KIRKLEES METROPOLITAN COUNCIL INVESTMENT & REGENERATION SERVICE

DELEGATED DECISION TO DETERMINE PLANNING APPLICATIONS

Reference No:	2025/62/93523/W
Site Address:	23, Moor Park Avenue, Beaumont Park, Huddersfield, HD4 7AL
Description:	Erection of two storey side and rear extensions and front porch, alterations to roof including increasing height of eaves and associated works
Recommending Officer:	Joanna Rednall

DECISION – Conditional Full Permission

Proposed Left Elevation
1 : 50

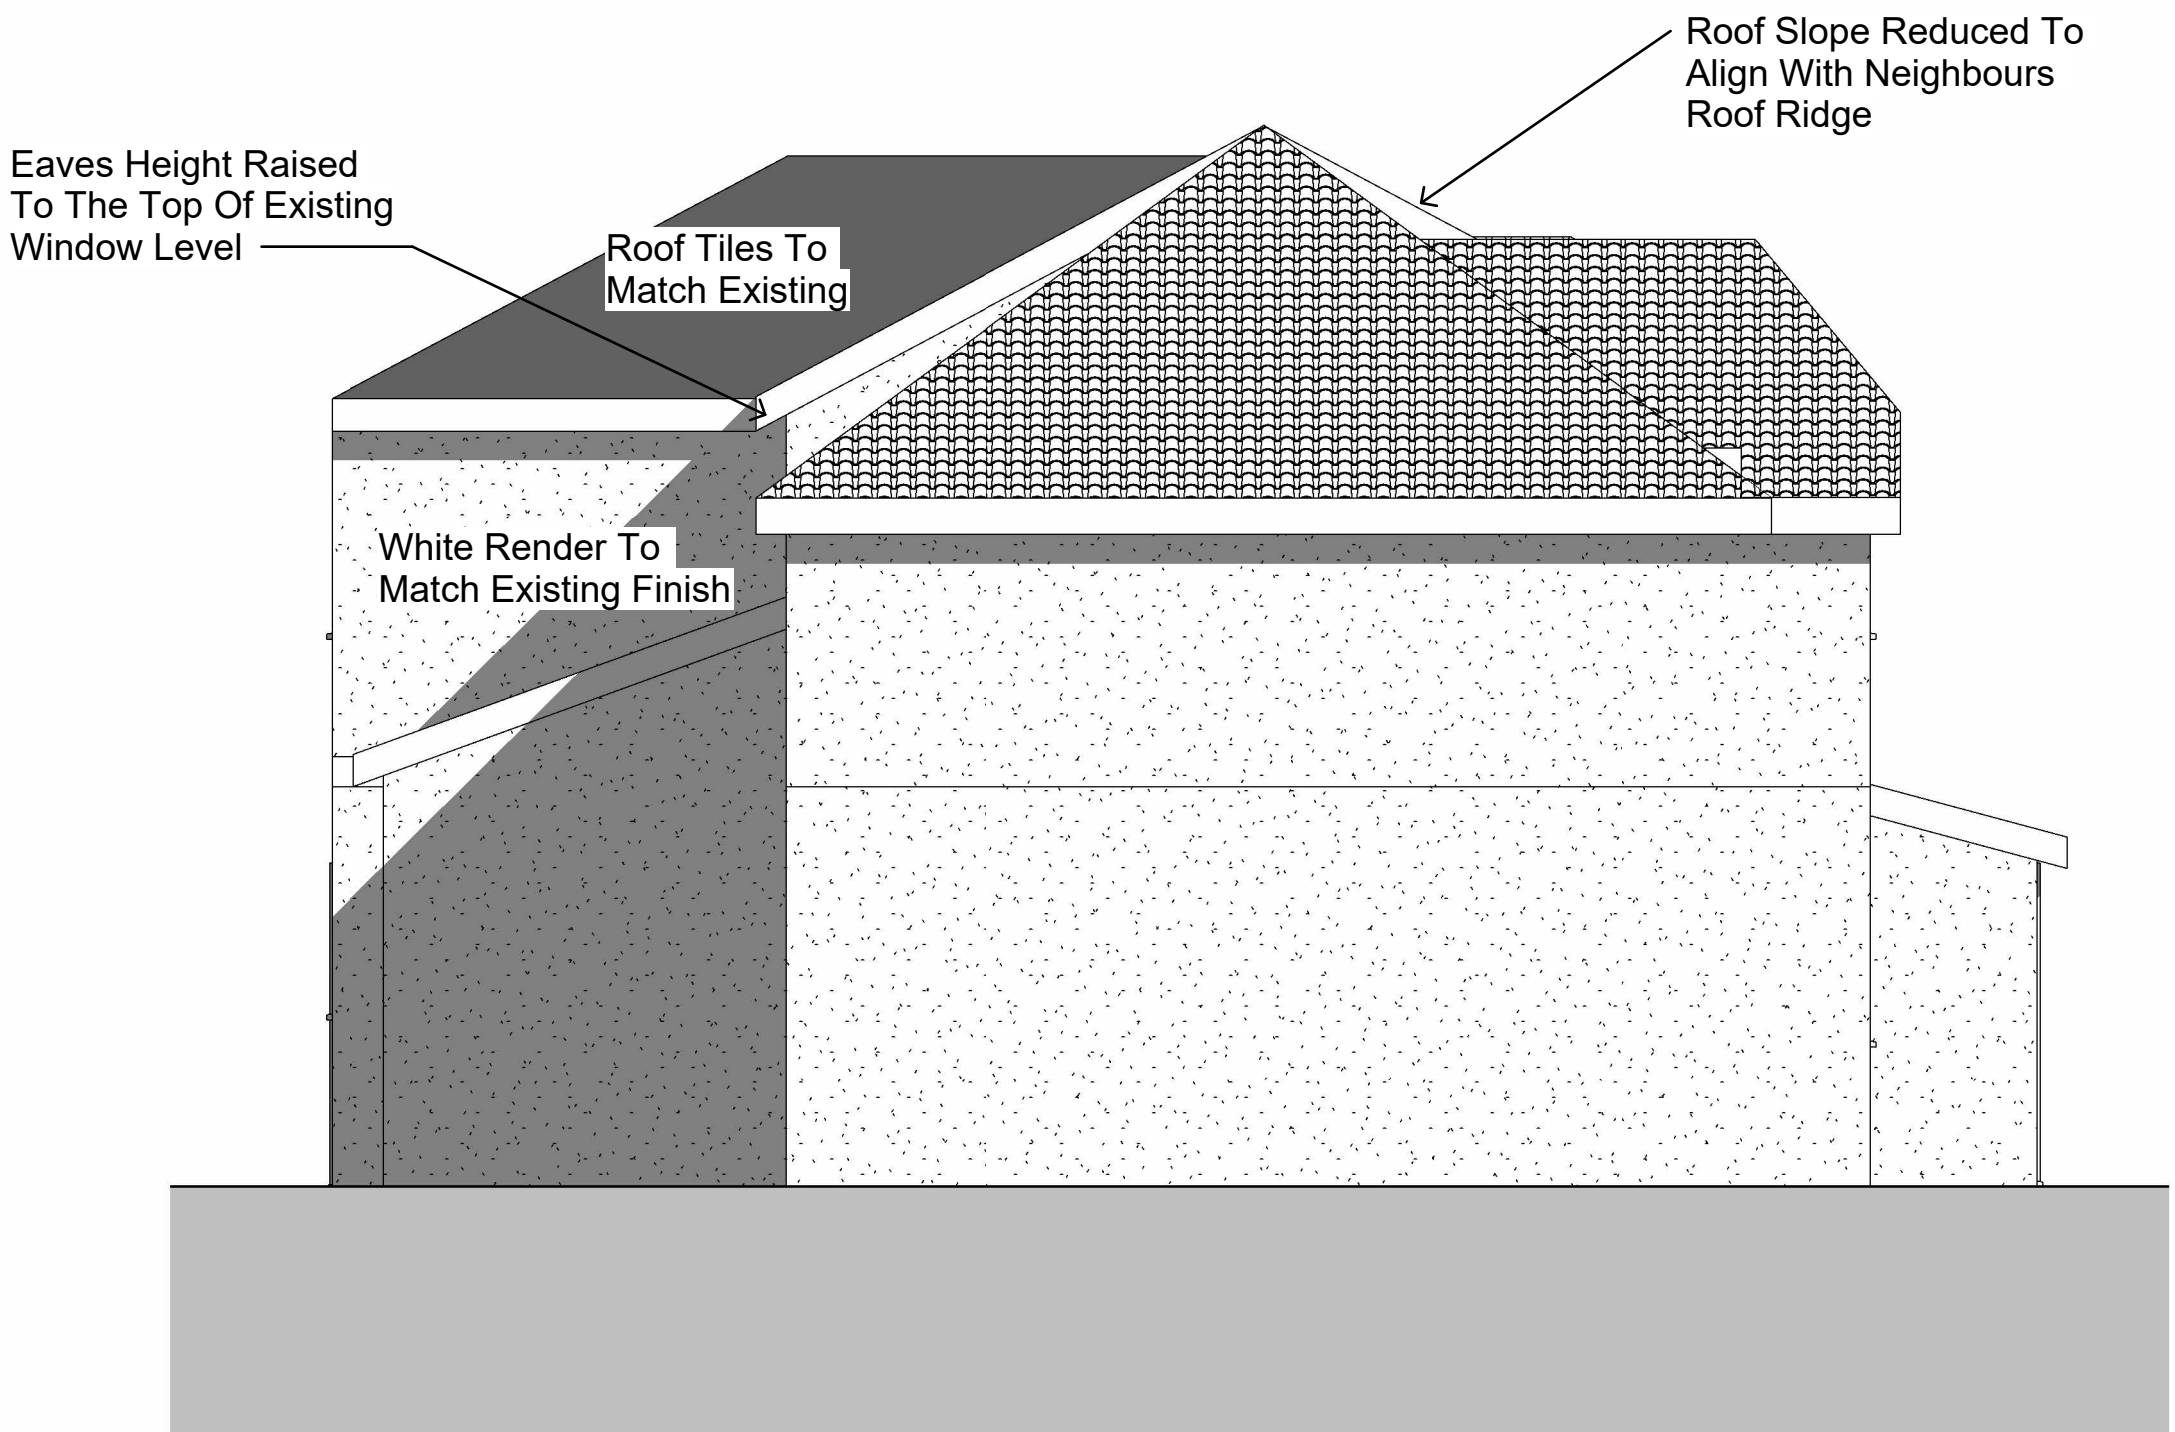
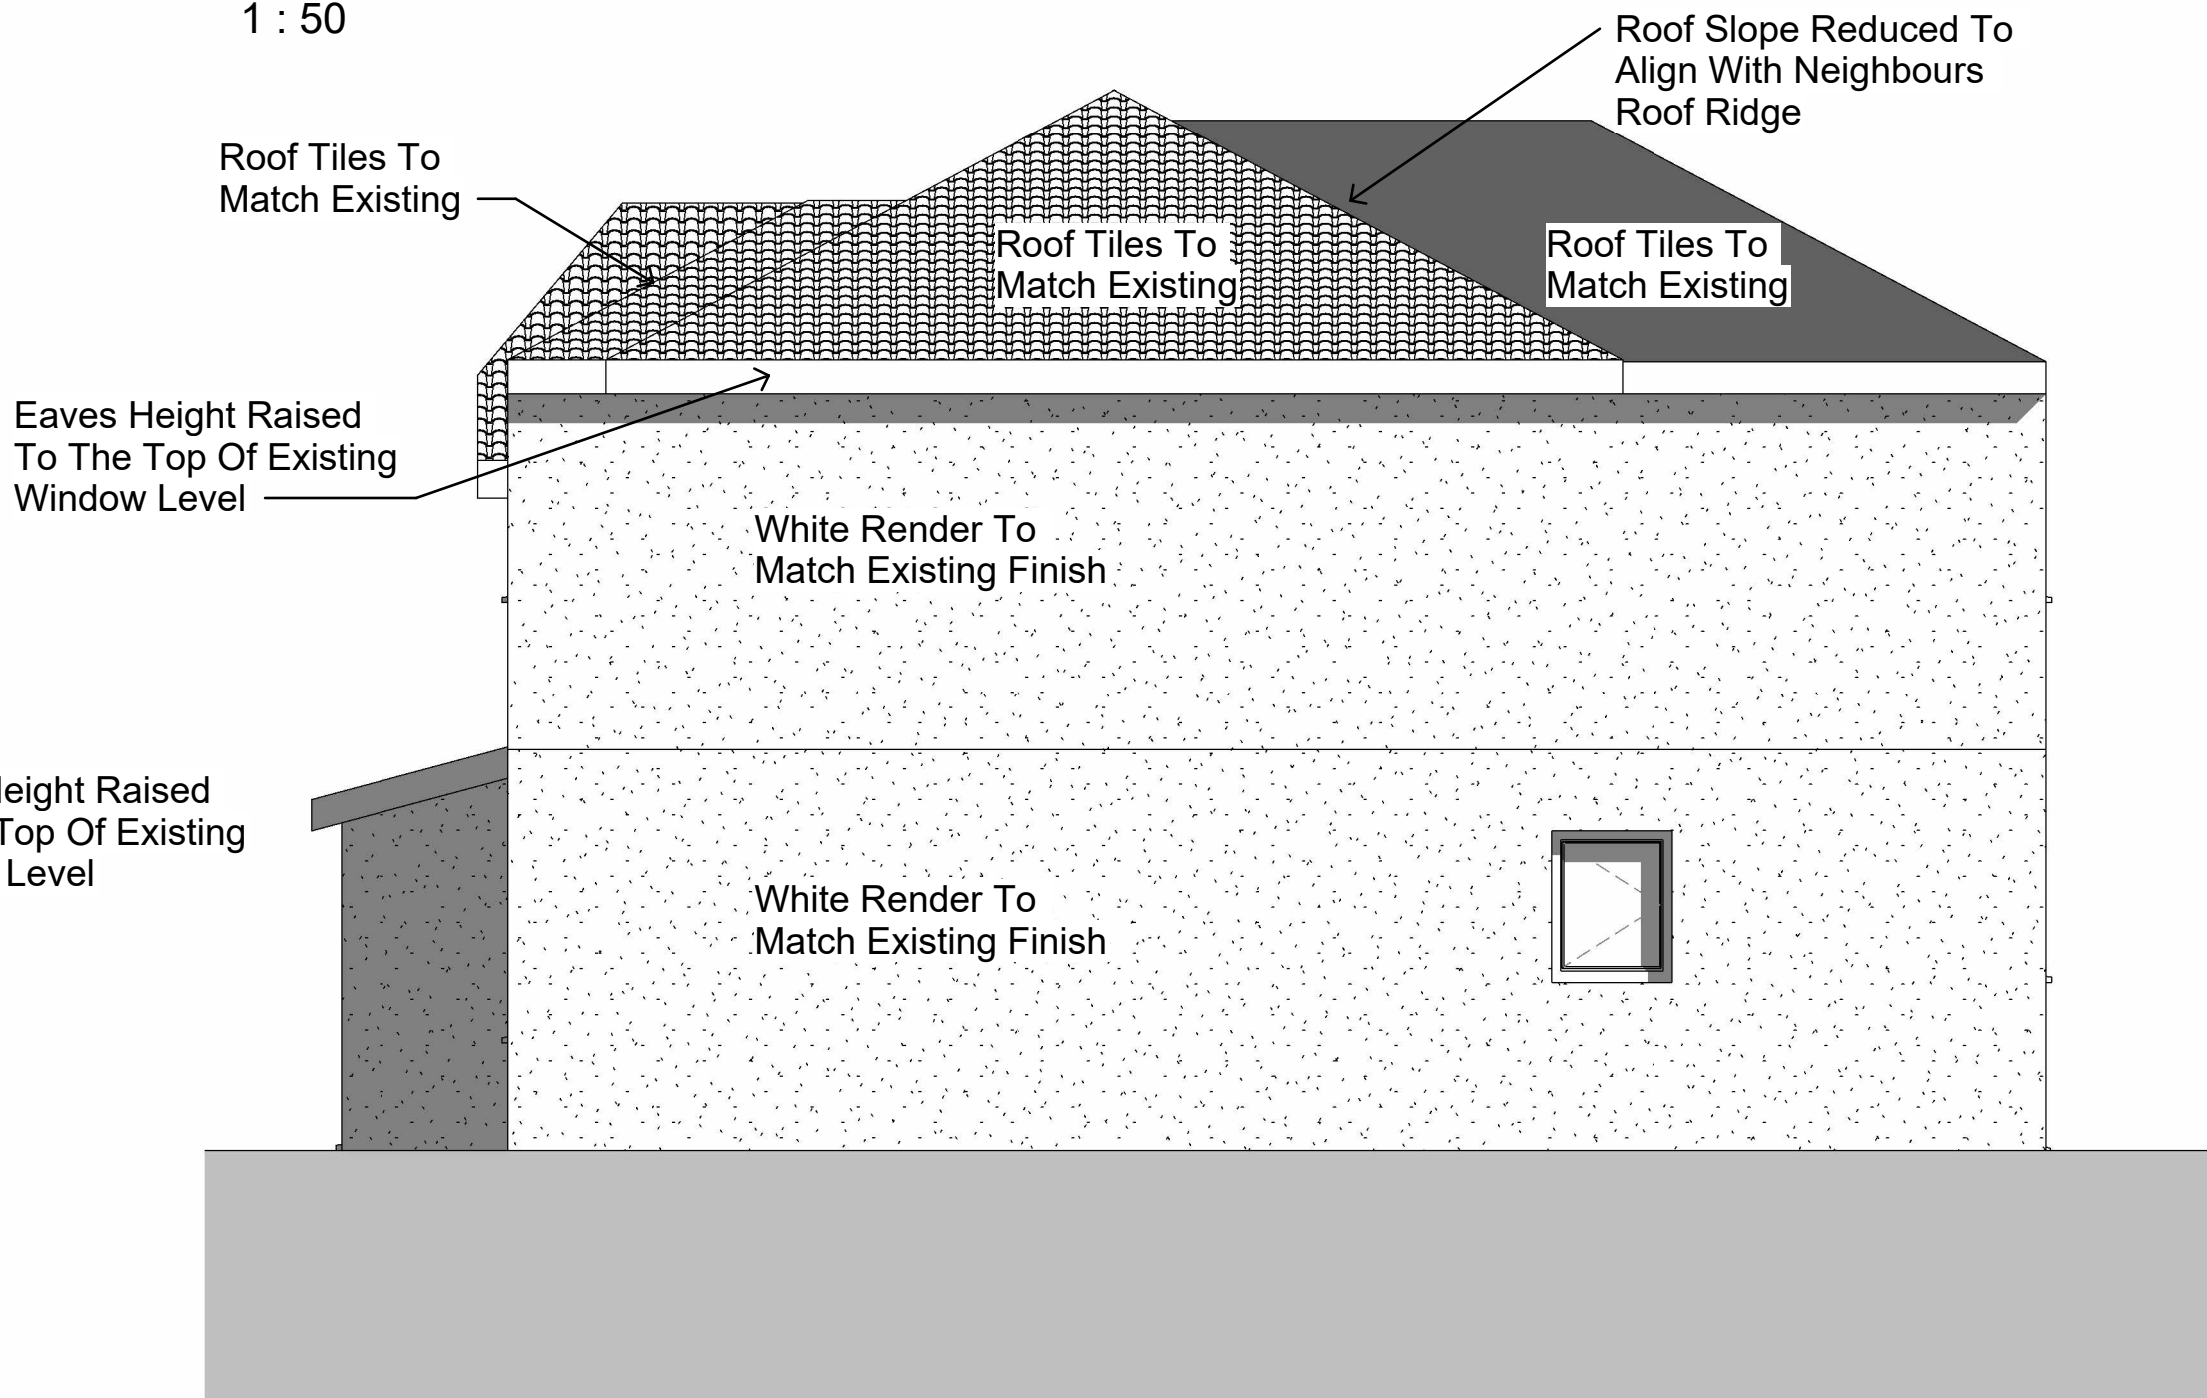
In this case, the proposed extension is large in scale and exceeds the parameters set out within the SPD. The extension would not maintain the recommended 1 metre gap to the side boundary, instead retaining a reduced separation of approximately 0.5 metres. However, paragraph 5.9 of the SPD states that: “*Larger extensions may be acceptable in certain circumstances if this can be justified, such as where neighbouring houses have already been extended, and will be considered on a case-by-case basis.*”

The SPD advises that adequate spacing between buildings should be retained to preserve a sense of openness, which is important to the character of an area. In this case, although the proposal would retain a reduced gap to the northern side boundary that falls below SPD recommendations, a degree of separation would nonetheless remain. The difference in ground levels between the properties would assist in preventing a terracing effect, while the hipped roof design would further reduce visual massing and help maintain a sense of space between buildings. While spacing between properties is characteristic of the area, it is also noted that surrounding dwellings vary in terms of design and scale, with the majority being detached. For these reasons, the two-storey side extension would not result in undue harm to the visual amenity of the area or the host property.

With regard to loss of light and outlook, the proposal would have the most impact upon 25 Moor Park Avenue to the north. The development would introduce additional bulk and massing at two-storey height closer to the shared boundary; however, it would remain set approximately 6 metres from the side elevation of No. 25 and would be partially screened by the existing detached garage serving that property. It is also noted that No. 25 occupies a higher ground level relative to the application site and contains windows facing towards it. Notwithstanding this, officers consider that the combination of the separation distance retained, the modest overall height of the extension, and the difference in ground levels would ensure that any change in outlook would not be overbearing or oppressive. Furthermore, the presence of existing built form between the two dwellings already limits the degree of overbearing, and the hipped roof design serves to reduce perceived bulk and orientate massing away from No. 25. For these reasons, the proposal would not result in a material loss of light or outlook or cause harm to the residential amenity of neighbouring occupiers.
